Charlotte Department of Transportation

Memorandum

Date: July 29, 2008

Subject: Rezoning Petition 08-125: Located on the southwest quadrant of Mount Holly Road and the I-485 Interchange

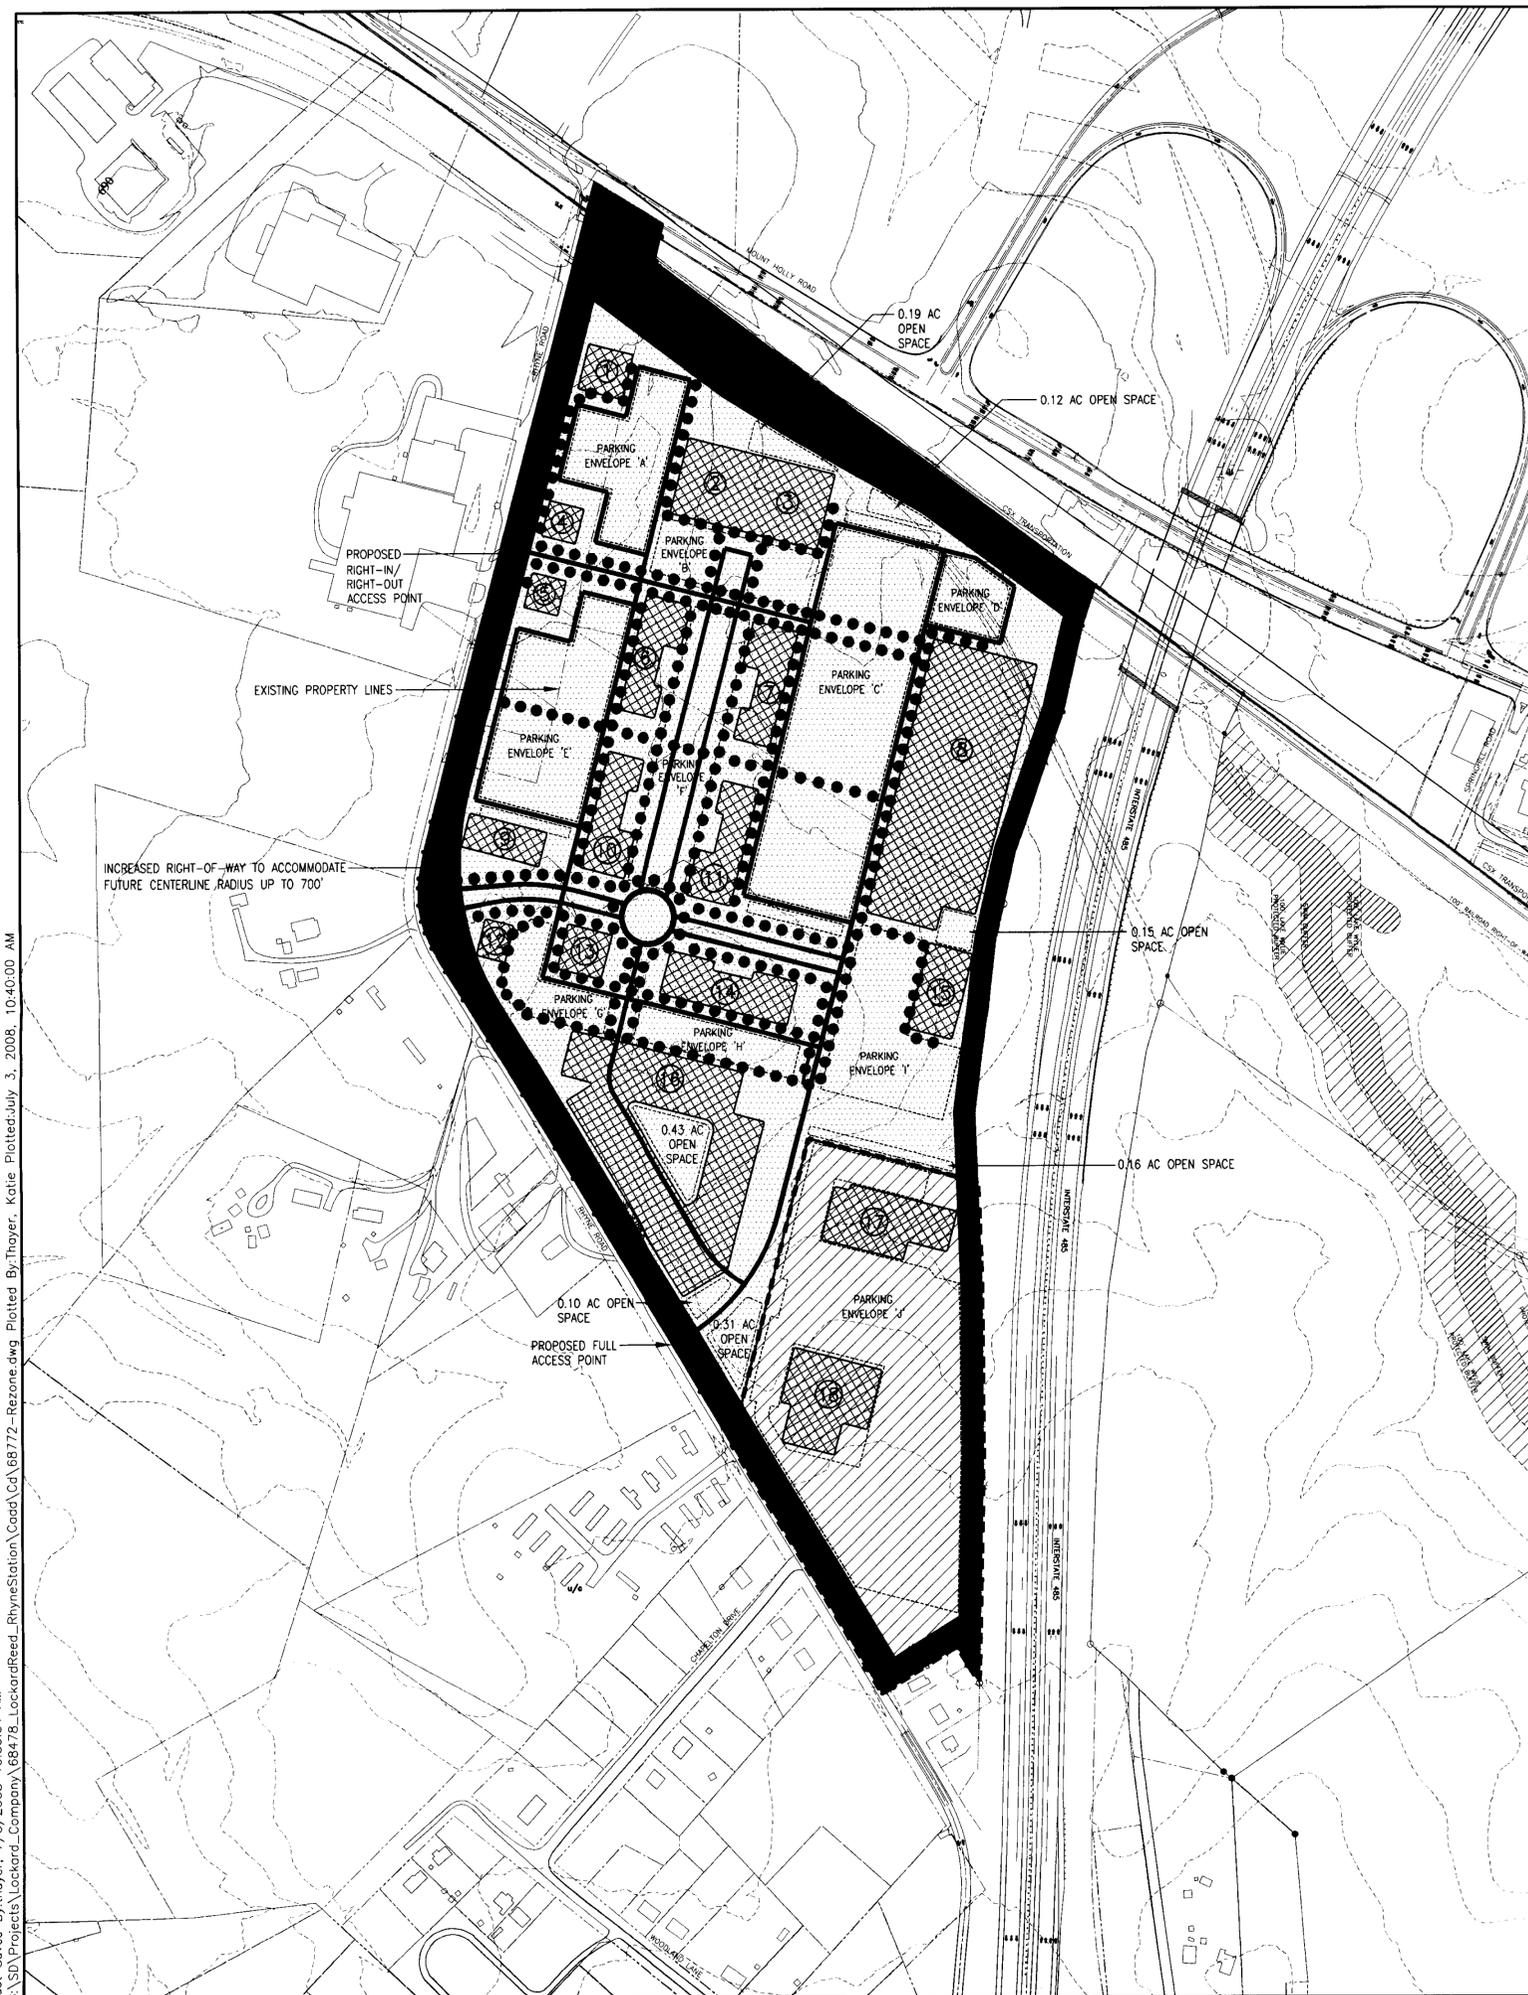
2. The proposed roundabout on driveway #2 cannot be used with dual left-turn lanes entering the site from Rhyne Road. The roundabout needs to be deleted.

3. Show the 8-foot planting strips and 8-foot sidewalks on all streets as required by conditional notes 1-4 under the section "Sidewalks and Internal Streets". All streets interior to the site can be private but must have the sidewalk and planting strip on both sides. This includes the road linking the roundabout (see comment 2) to the car dealerships. 16-foot hardscapes with trees in tree pits may be an acceptable alternative in certain circumstances.

4. All streets listed in comment 3 need to be constructed as part of the initial site development to provide a good internal street network. The portion of the street through the townhome section cannot be deferred until development of the townhomes occur.

1. Provided that NCDOT concurs, the southernmost driveway to Rhyne Road can be designed to allow left-in movements instead of being restricted to right-in/right-out movements only.
2. To better accommodate pedestrians, the townhomes need to be alley-loaded instead of front-loaded.
